# Urban Design Review Panel Report - Revision 1

## 500 Coventry Road, Ottawa

**RE: Urban Design Review Panel Report – Revision 1  
Site Plan Control Application  
500 Coventry Road, Ottawa**

Enclosed, please find responses to the Urban Design Review Panel's comments provided on February 2, 2024, regarding the Site Plan Control application for the property municipally known as 500 Coventry Road, Ottawa.

DRAWING NO. SPA005A	REV. 3
------------------------	-----------

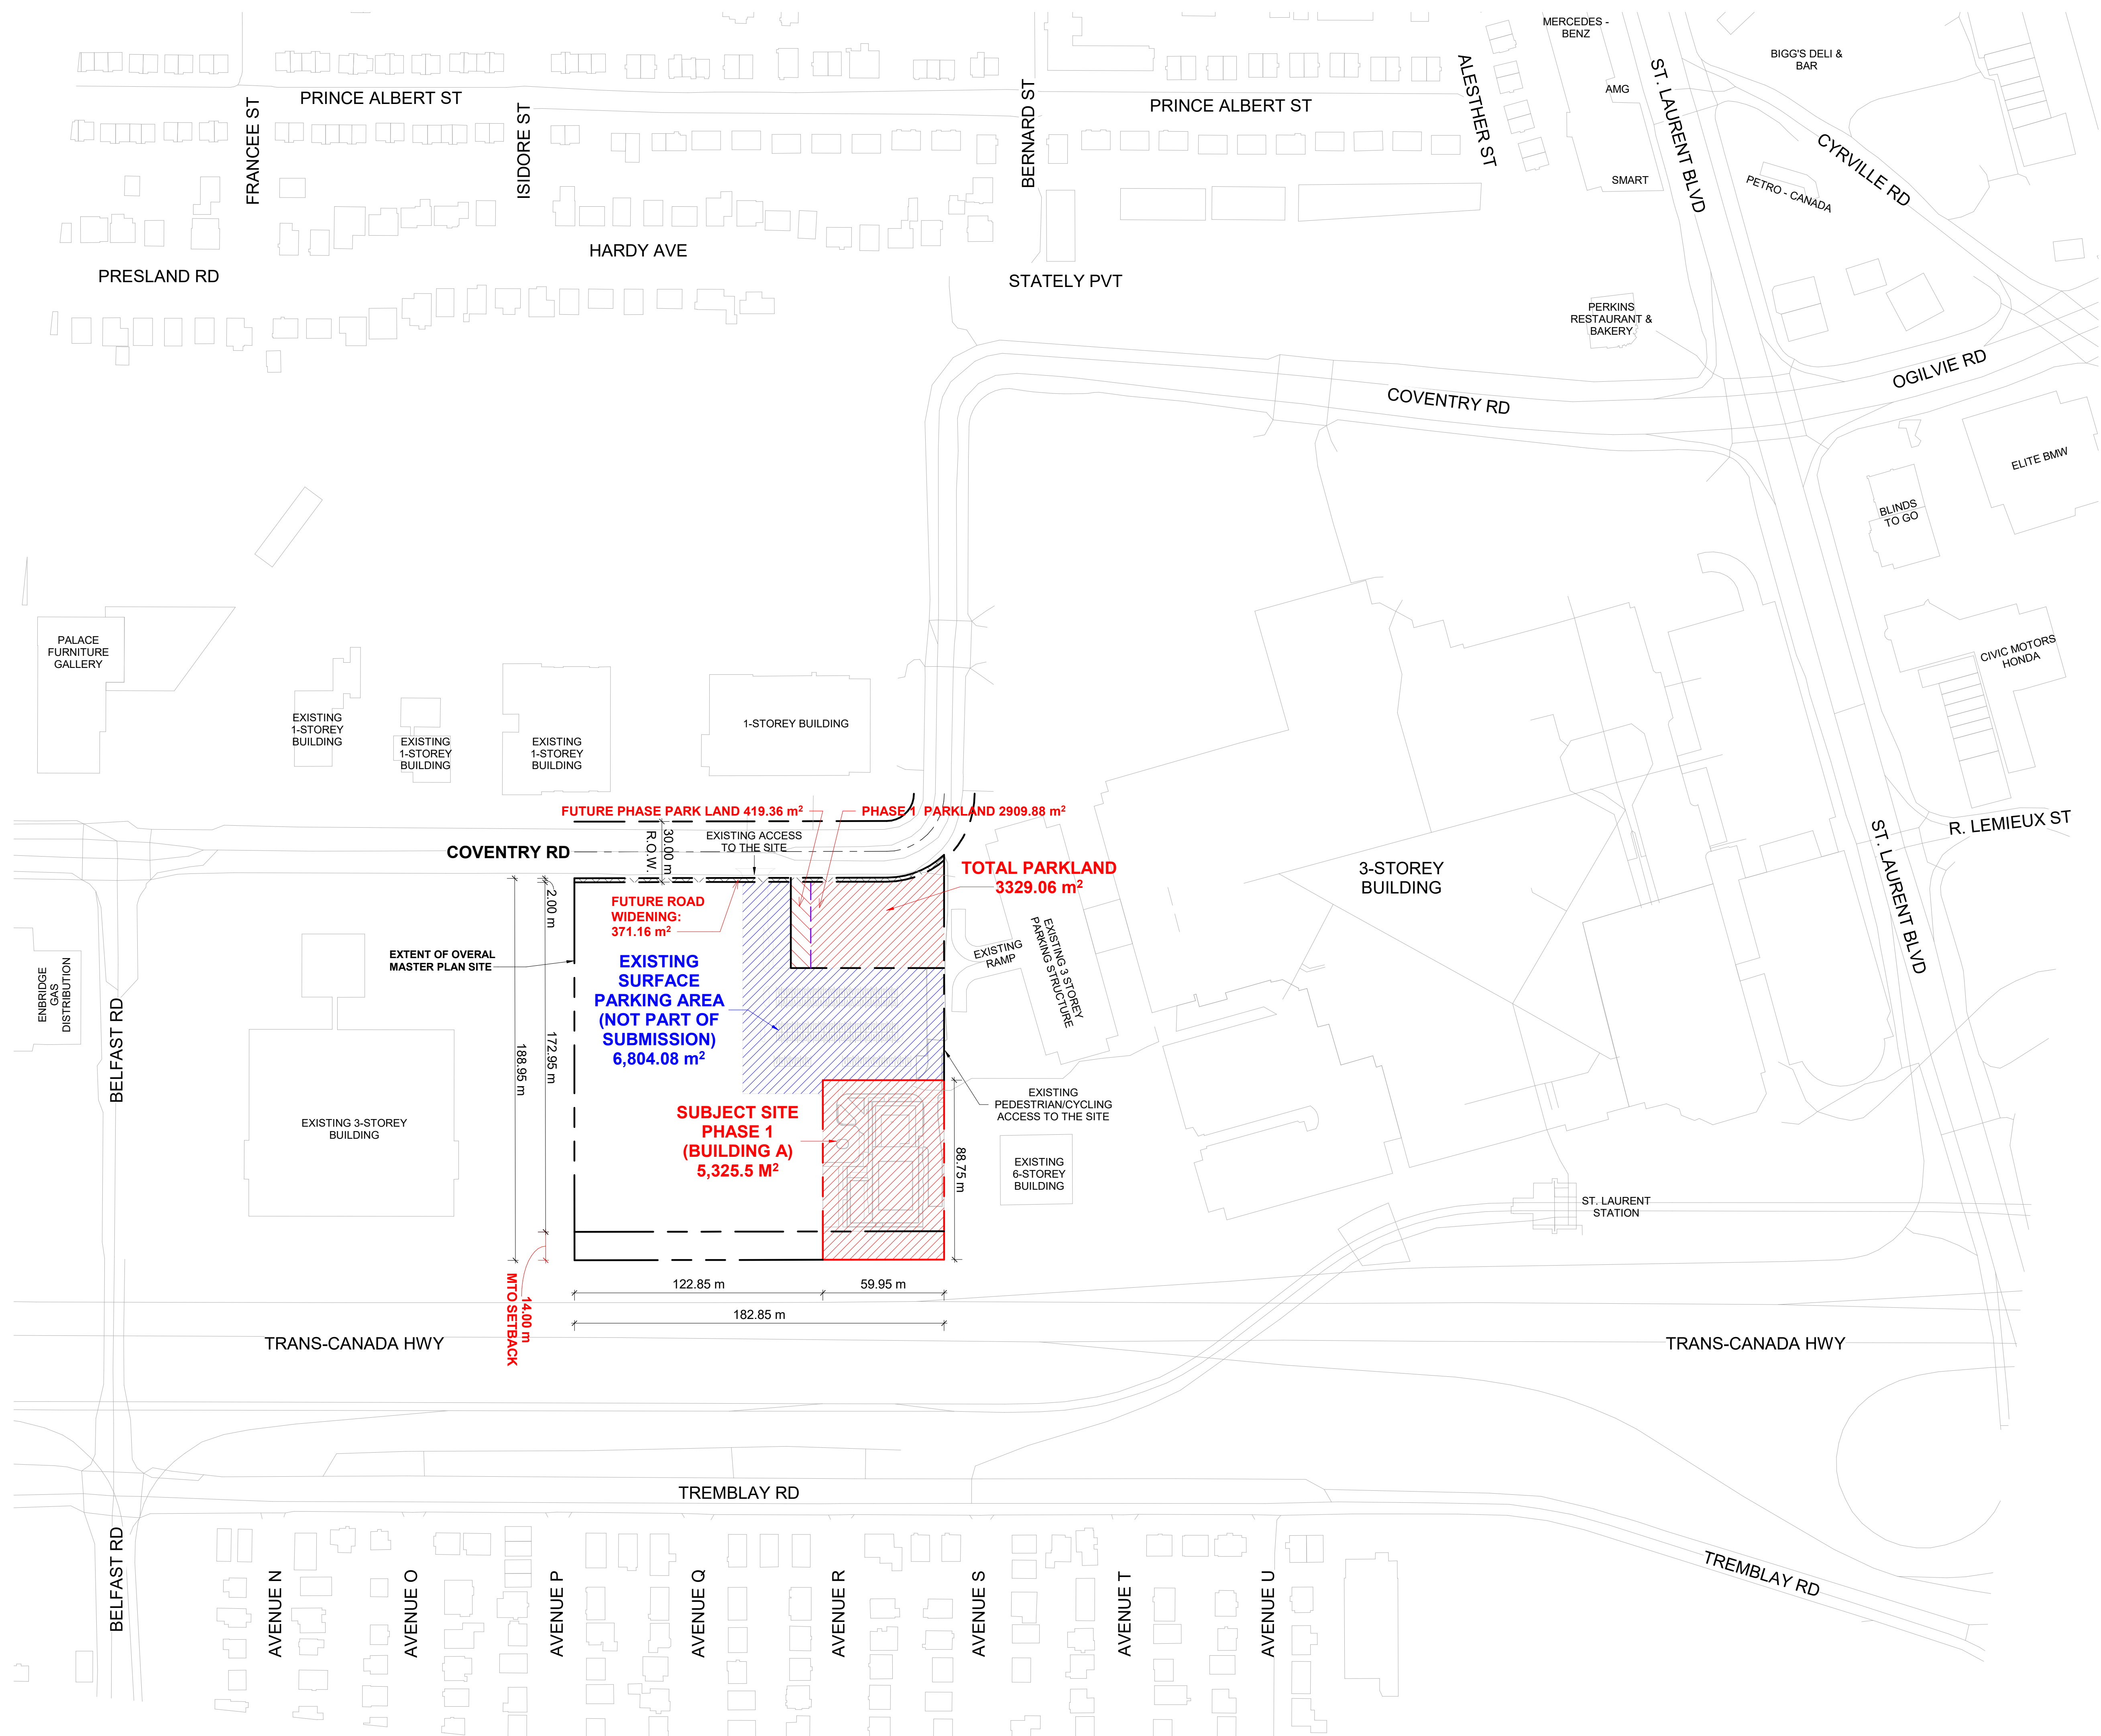
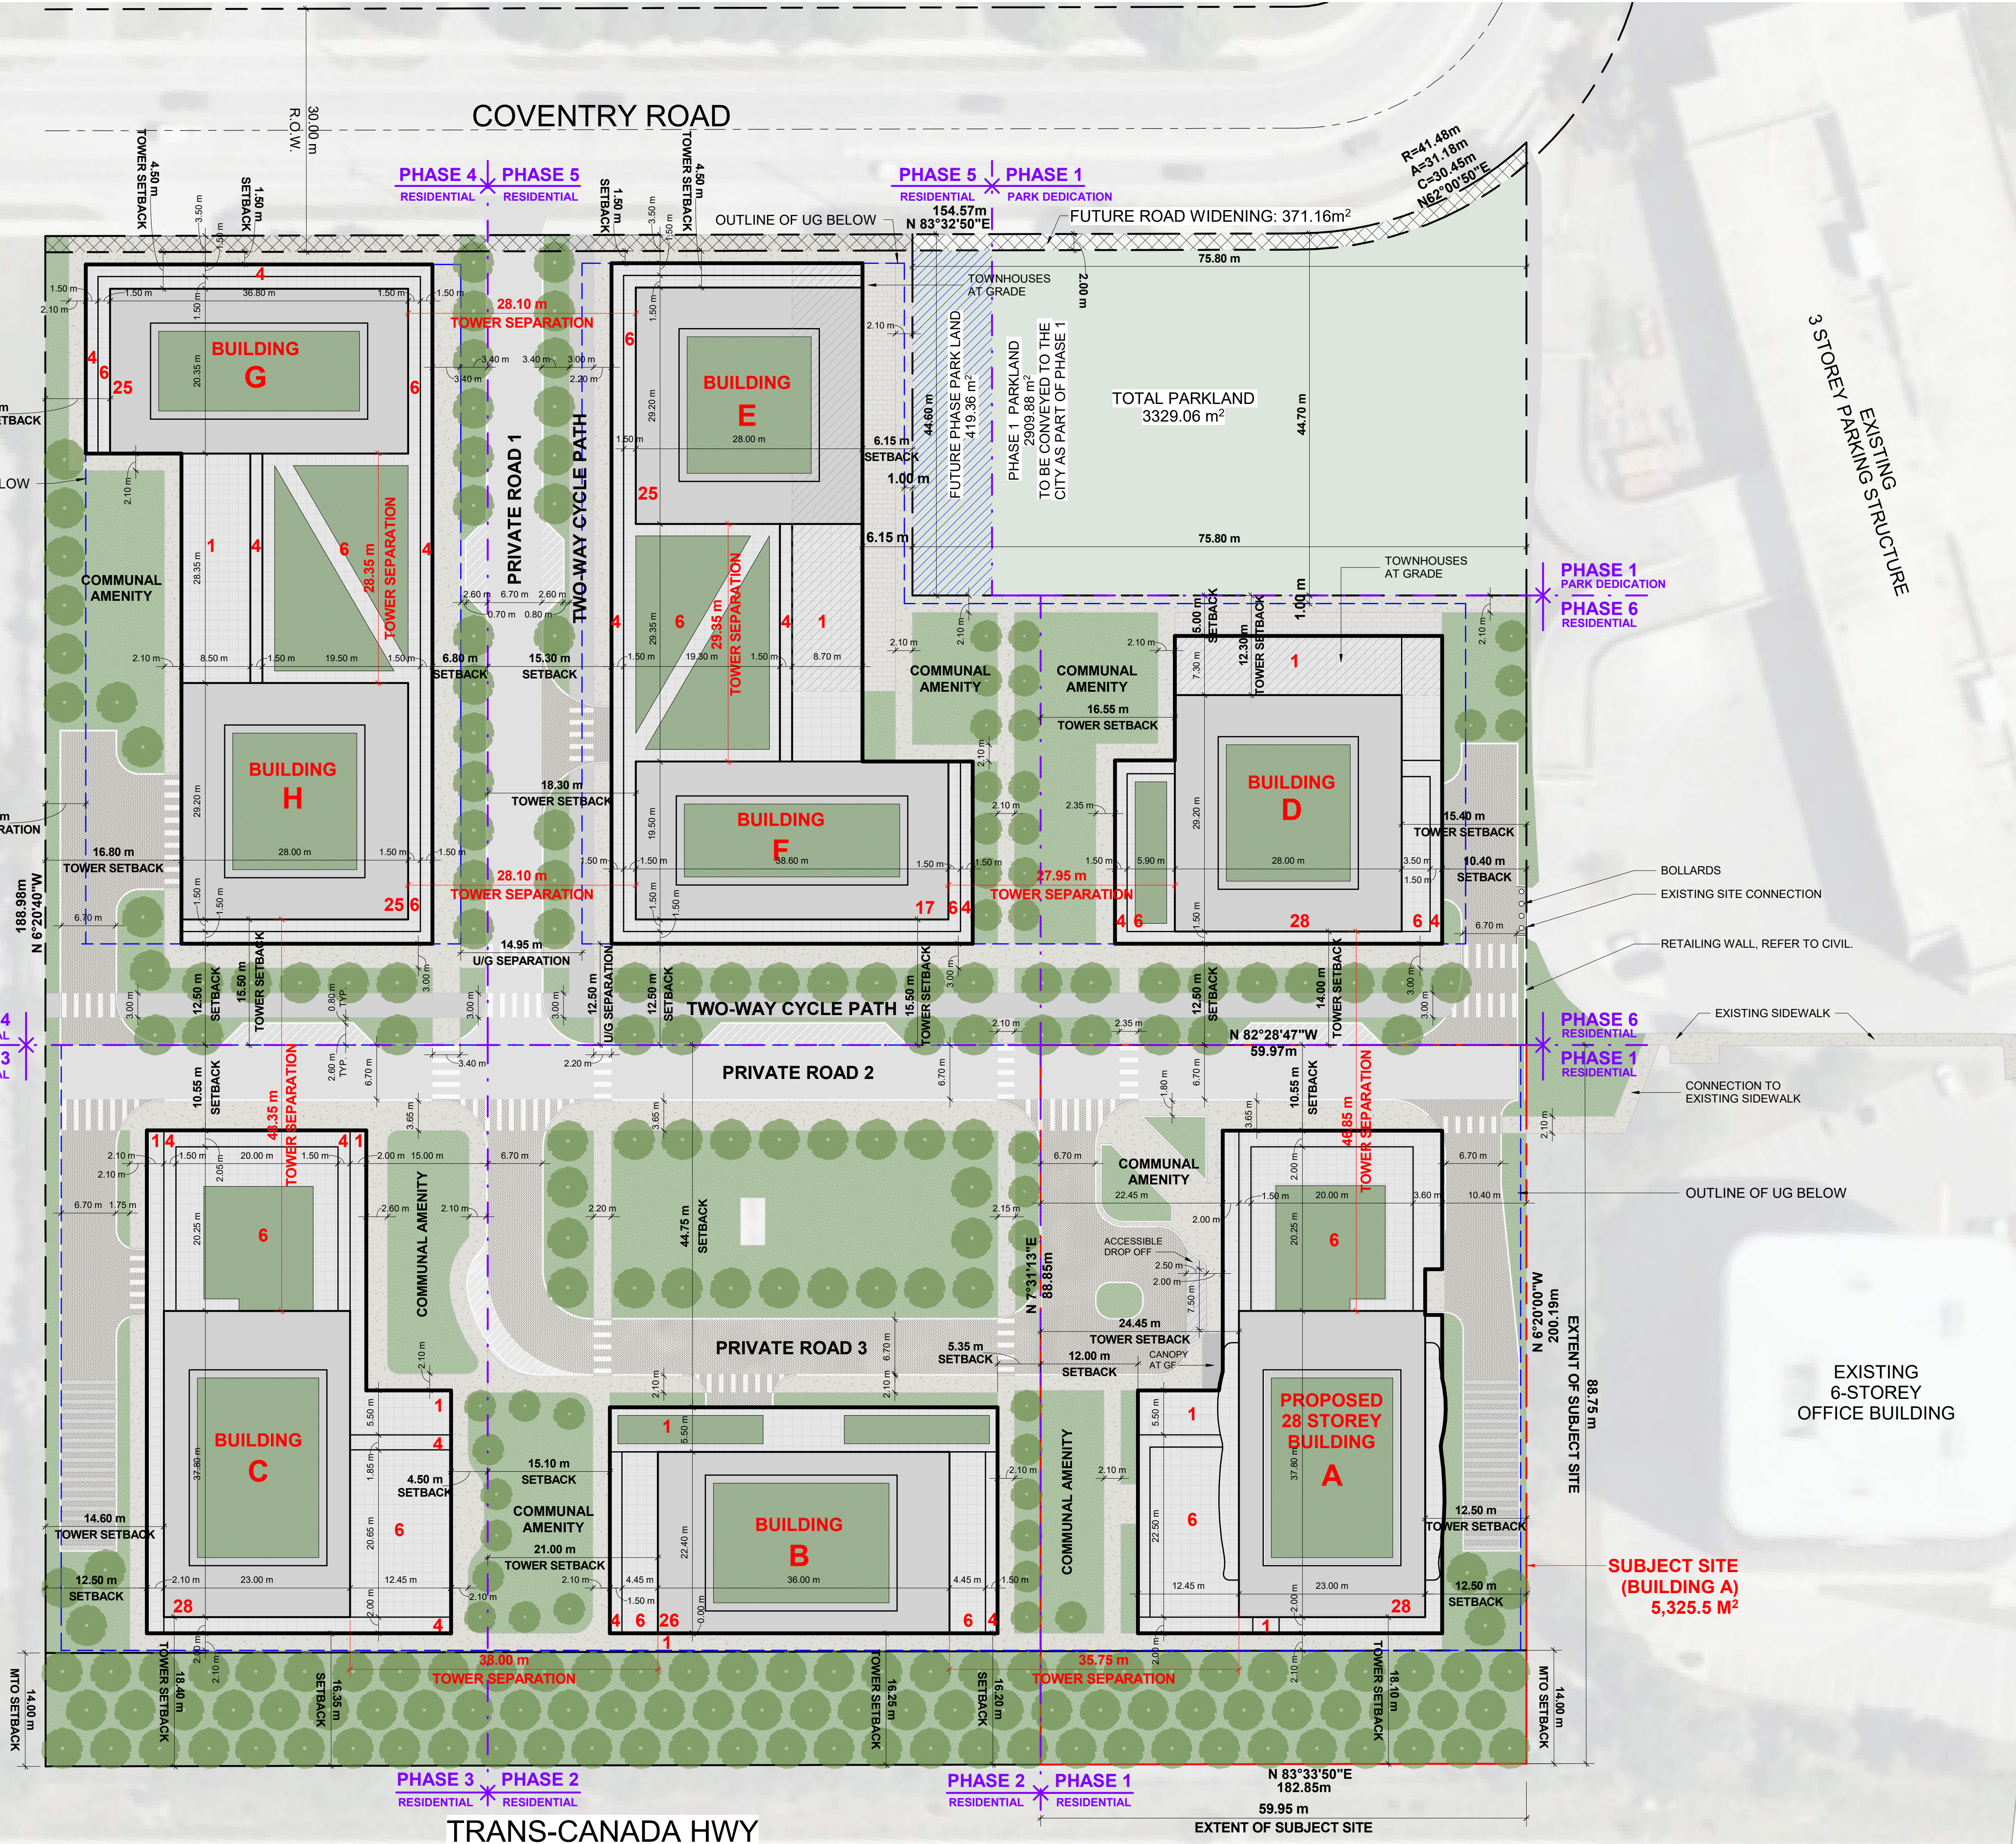
2. The Panel strongly recommends more thought be given to creating a pedestrian-first built environment and layering to the Phase 1 Master Plan presented (p.26), as it currently appears overly vehicle oriented.

3. The Panel recommends further exploring ways in which the vehicle-oriented roads can be evolved into pedestrian-oriented streets, with consideration of how these streets will be activated/animated with pedestrians.

6. The Panel recommends the dedicated parkland be lined with grade-related units to further activate the park space, and that vehicular uses such as loading/drop-offs be relocated away from the park.

7. The Panel recommends further exploring how best to terminate long views with architectural interest. Consider opportunities for communal pavilion spaces and/or sculptural elements to help anchor views and bring people in the community together.

8. The Panel has concerns about the underground parking ramps being exposed and highly recommends tucking the parking ramps within the building envelope.

13. The Panel appreciates that this master planned area, and Coventry Road more generally, presents a challenging landscape to establish a new high-rise community.
- The Panel has strong concerns with how this master planned community will establish a robust and pedestrian-first public realm environment, given its existing light industrial and car-oriented commercial character.

15. The Panel recommends adding more linkages through the site to the dedicated parkland on the corner.
- For example, connect pedestrian green space between Building F and Building D to create amenity spaces for pedestrians instead of multiple loading and drop-off areas.
  - Consider connecting the communal amenity to other pedestrian areas, rather than the existing 'island' effect presented by surrounding vehicular circulation.
  - The Panel recommends dialing back the vehicular components of the master plan in return for a more pedestrian-first public realm environment. Pedestrians ought to be the highest order of mobility in the master plan.

16. The Panel recommends exploring designs for a pedestrian pathway that wraps around the site on all sides and connects the amenity spaces to the outdoors.

23. The Panel appreciates the long axial views provided in the Master Plan and recommends further exploring the role of long views into and through the Master Planned site.

**Response: Master plan design has been revised to be more pedestrian oriented with less paved road. Refer to sheet SPA005A.**

**Response: Master plan design has been revised to be more pedestrian oriented with less paved road. Refer to sheet SPA005A.**

**Response: Townhouses at grade have been provided and loading has been relocated. Refer to sheet SPA005A.**

**Response: Communal amenity areas have been proposed at the terminal of each long views, with the potential to add landscape and public features. Refer to sheet SPA005A.**

**Response: Majority of ramps have been internalized. The addition of a parking ramp structure has been designed to partially cover the ramp, tying it into the design of the building. Refer to sheet SPA005A.**

**Response: Master plan design has been revised to be more pedestrian oriented with less paved road. Refer to sheet SPA005A.**

**Response: Pedestrian green space provided between building D and F, amenity areas are more interconnected, and more focus on the pedestrian was introduced to the updated master plan design. Refer to sheet SPA005A.**

**Response: Pedestrian pathways provided on the interior of the site but not the perimeter to bring the focus back on the community inside the master plan. Refer to sheet SPA005A.**

**Response: Communal amenity areas have been proposed at the terminal of each long views, with the potential to add landscape and public features. Refer to sheet SPA005A.**
